15 December 2021

Our Ref: R/2020/14/A and R/2016/20/D
File No: 2021/530190
Your Ref: SSD-9978934 and SSD 7684 MOD 1

Request for advice - Cockle Bay Park Redevelopment - Modification to Stage 1 (SSD 4684 MOD 1) and Stage 2 (SSD-9978934)

Figure 5: Measurement locations with comfort/safety classifications

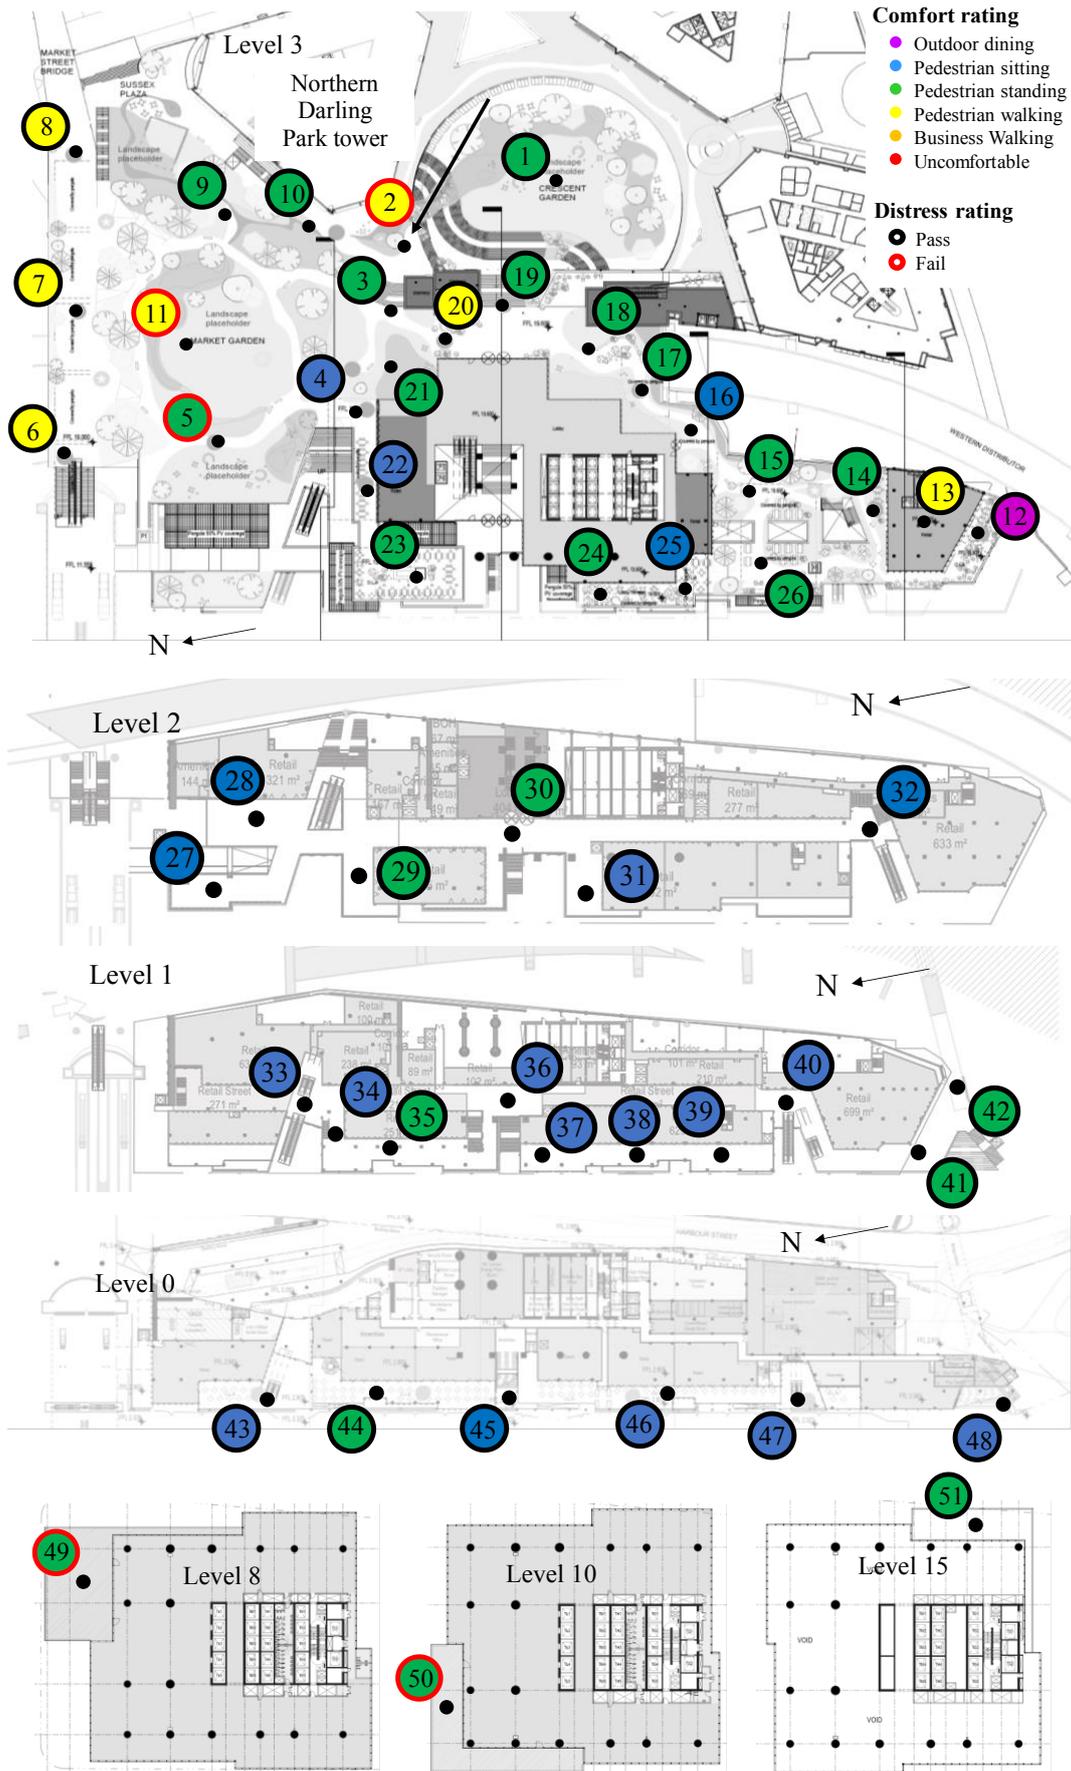
It is noted that the Environmental Wind Assessment Report, prepared by Arup, identifies 3 points, being numbered 2, 5 and 11, that fail the comfort criteria for pedestrian standing and walking. These points all have a result of >24m/s which can be described as dangerous conditions for abled bodied people, not considering the elderly and children. The wind assessment identifies these impacts as a function of the isolated tower massing. The singular tower form is a product of the approved concept plan and as such the wind impacts would have been considered at the concept DA stage.

The wind assessment recommends the inclusion of more canopies. The City notes that there is a balance to be struck in providing wind protection that does not result in more visual clutter and bulk caused by additional canopies.

## Podium North

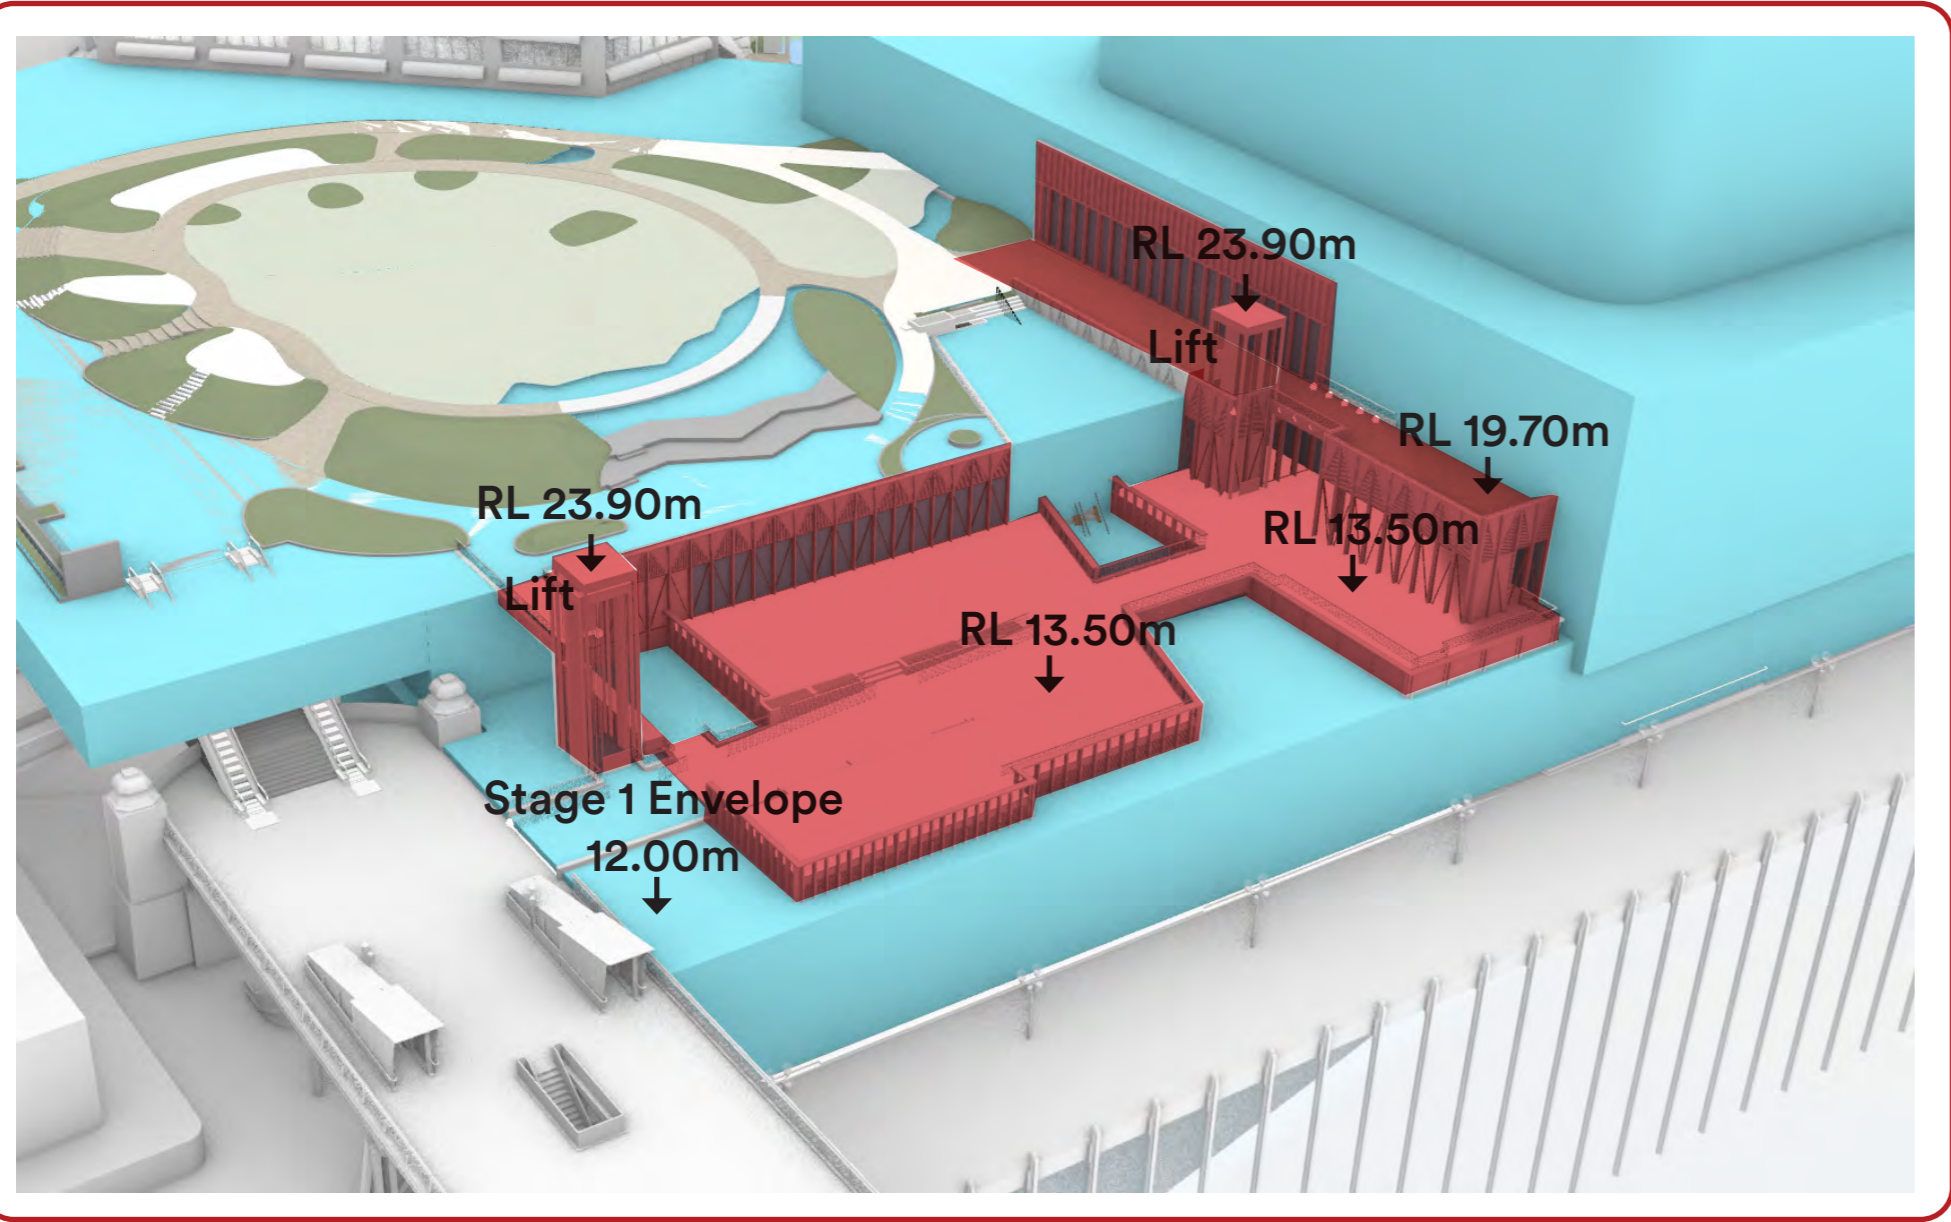
The northern part of the podium at RL13.5 is higher than the approved Concept Plan of RL 12. The approved concept plan with the proposed maximum height being commensurate with the balustrade of the Pymont Bridge was to ensure that the building did not affect an expansive view of Darling Harbour and the curtilage of the Pymont Bridge. The increased building bulk and height at this part of the site limits the field of vision and views towards Darling Harbour upon approach from the east and should be examined for reducing the height where possible.

Similarly, the proposal should provide a curtilage to the Pyrmont Bridge at the promenade level. As proposed, the development removes the existing landscaped buffer and reduces the setback from the Pyrmont Bridge. The proximity of the proposed building and retail at the north-west corner of the podium impacts the visibility of Bridge, notably its truss and stone pylon.

Therefore, the City recommends that the north-west corner of the podium be redesigned so that its western edge allows the Bridge and its elements to be more legible. This can be achieved by aligning the western edge of the podium with the edge of retail tenancies or by providing a setback and separation to the Bridge that emulates the existing building. This would also retain the movement of pedestrians at this key point along the water promenade. Refer to **Figure 2** below.

# Pymont Bridge connection

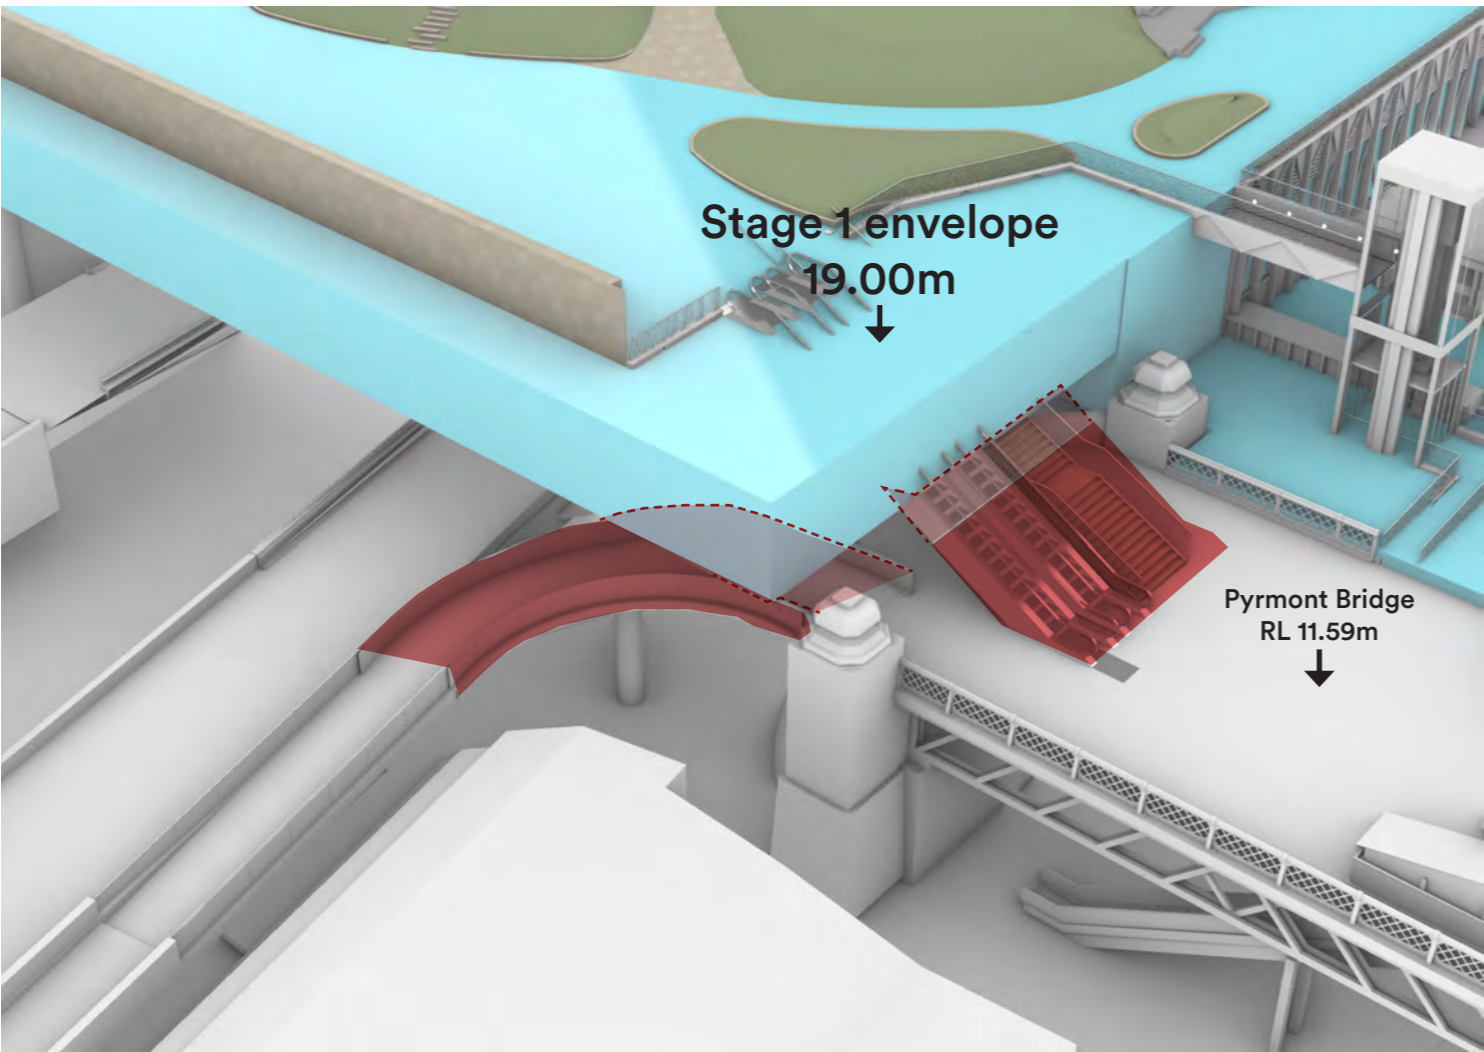
The land bridge to Market Street is superimposed on the eastern end of Pyrmont Bridge. The proposed pergola structure, along with the proposed elevated garden to the south, is perceived to intercept the Bridge. When viewed from the west, the Bridge appears to run under or into the proposed podium. As a result, the Bridge's role as a link of two districts is compromised. The historic relationship of the Bridge and Market Street, and the vista along the Bridge towards and with the CBD building clusters should be maintained and not obstructed by the proposed elevated linking bridge and garden at the northern end of the development site. The Bridge should read as an independent structure – this requires reconsideration with more openness and respect to the heritage bridge.

To reduce impacts to the Pyrmont Bridge, the City recommends that sight lines from the bridge towards the west and south-west be retained, be free from building elements or be no higher than 11.55 metres. To also improve the heritage curtilage of the development, it is recommended that the walled edge of the land bridge and the podium be softened. These vertical 'cliffs' can be replaced by landscaped terraces. The distance between the pylons and the northern podium at RL19.6 should also be increased to maintain an adequate visual curtilage for the two pylons. The proposed escalators, stairs and the cover canopies affect the sightlines between the two stone pylon and are intrusive to the Bridge. They should be shifted to the eastern side of the pylons. Refer to **Figure 1** below.

Consider how to retain the routine of the existing foot bridge connecting Pyrmont Bridge with Market Street as the northern edge of the land bridge and elevated open space at RL19.6.

# Market Street Bridge connection

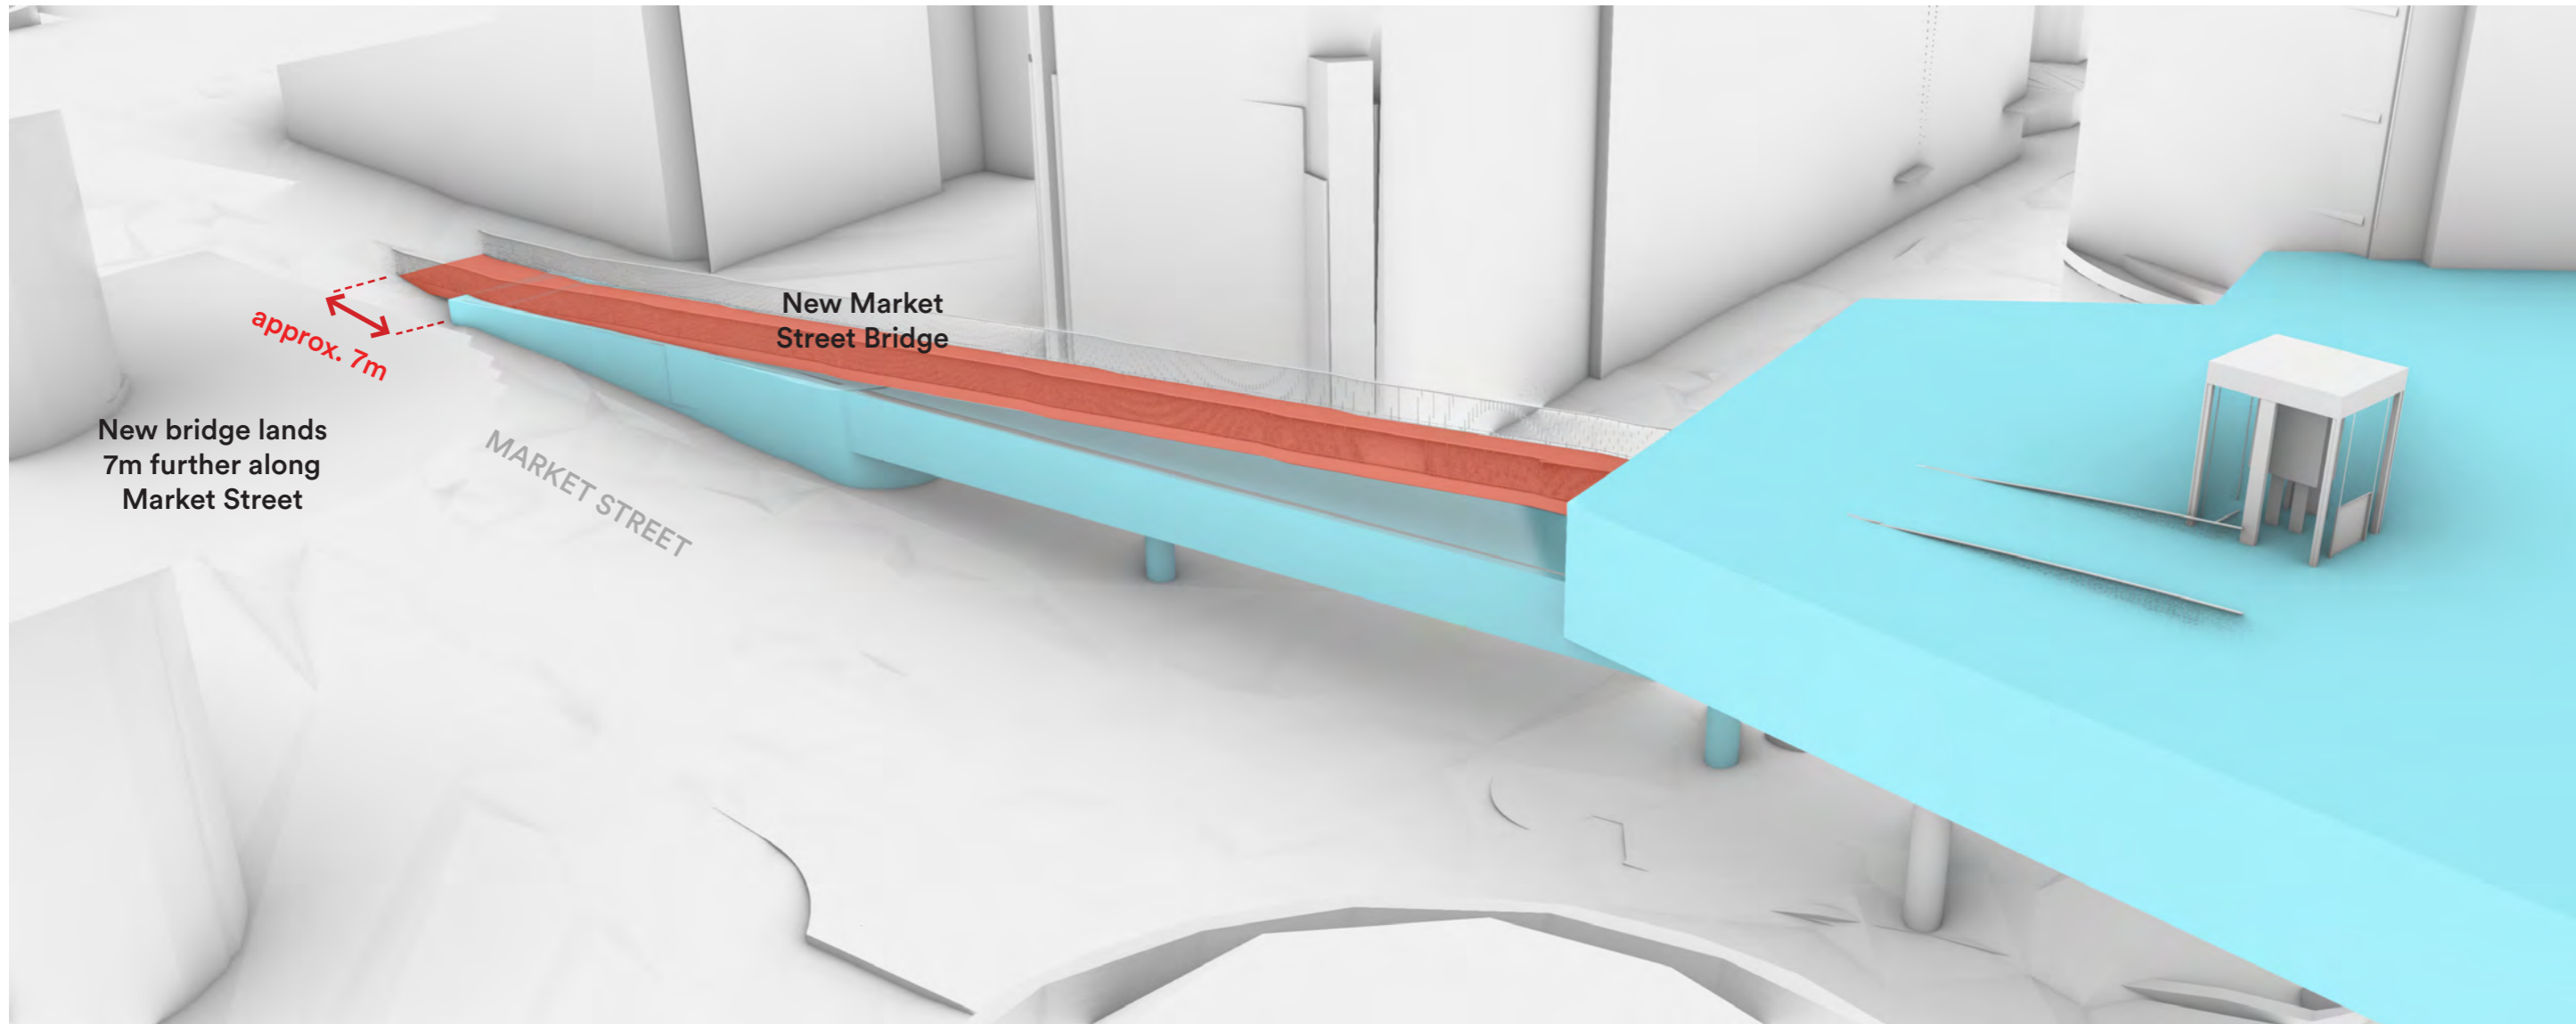
In order to make up the height difference between the existing Market Street pedestrian bridge and the proposed land bridge, a steeper and longer ramp is required. This extends 7 metres further along the Market Street footpath and at a 1:14 stepped gradient. The increased length and steepness of the ramp up to the

land bridge has a more significant impact upon the public footway in Market Street. It will have some impact upon accessibility due to its length and number of ramps at 1:14. A lift from Sussex Street is proposed to mitigate this issue. However, the lift is partly concealed by trees and other structures within Sussex Plaza and is not easily visible. The City recommends that the physical connection from Sussex Street and Market Street should strive to break up the large difference in height by progressively adjusting the ramp and climb height where possible. This aspect will require owners consent from the City prior to determination.

Additionally, the form of the land bridge consumes the Market Street pedestrian bridge into the new artificial ground level. As a result, it would not be perceived as a bridge element that is transparent and allows views to the City, but rather the northern edge of the park, with a walled or screened edge. The increased bulk of the land bridge has a negative visual impact. This is reinforced by the more solid nature of the northern edge of the land bridge comprising of the solid walls, planters, and seating. The solid expression of the northern edge of the land bridge visually competes with the solidity of the heritage listed Pymont Bridge. Together with the proposed pergola, the bulk of the development removes the openness and visual sight lines from the City to Darling Harbour and vice versa. It is the City's strong recommendation that these elements be removed to maintain as close as possible to the existing open and transparent visual connections from the City to the harbour. This would also address other issues relating to heritage that will be discussed below.
